# Planning Services Sign Permit Review Form

Date of Submittal	Application Number	Applicant	Landowner
8/03/2021	SIGN2108-0001	Grey Outdoor LLC	STKI Leasing LLC

Reviewed By:	Date of Review	Review Results
<b>Sarah Arbour</b>	<b>8/13/2021</b>	<input type="checkbox"/> Approved <input checked="" type="checkbox"/> Disapproved

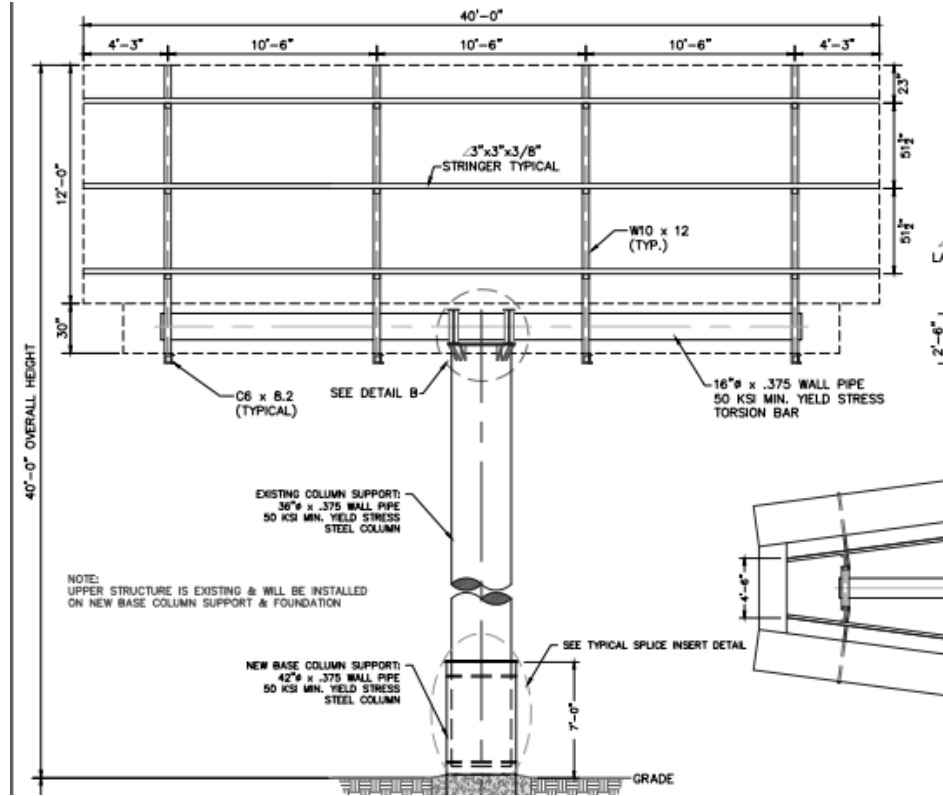
Comments	<p>General Sign Information: The sign is classified as a Business Sign: Interstate Highway. The sign is not licensed with NCDOT as a billboard. The sign <b>cannot be used</b> for the purposes of off-site advertising – now or in the future.</p> <p>Comments</p> <ol style="list-style-type: none"> <li>1. Update the site plan to show the location of the new edge of ROW and indicate the distance from the relocated sign to the ROW. A minimum of 50' is required by NCDOT from the ROW.</li> <li>2. Please be advised that only 1 business sign is permitted on the property. No other ground sign advertising for the property will be permitted. Please illustrate this on the site plan or in writing as a part of the permit package that no other business signs are located on the property.</li> <li>3. The pool attached to the sign in the rendering will not be permitted when the sign is relocated. Please update the sign rendering to indicate that the pool has been removed.</li> </ol>
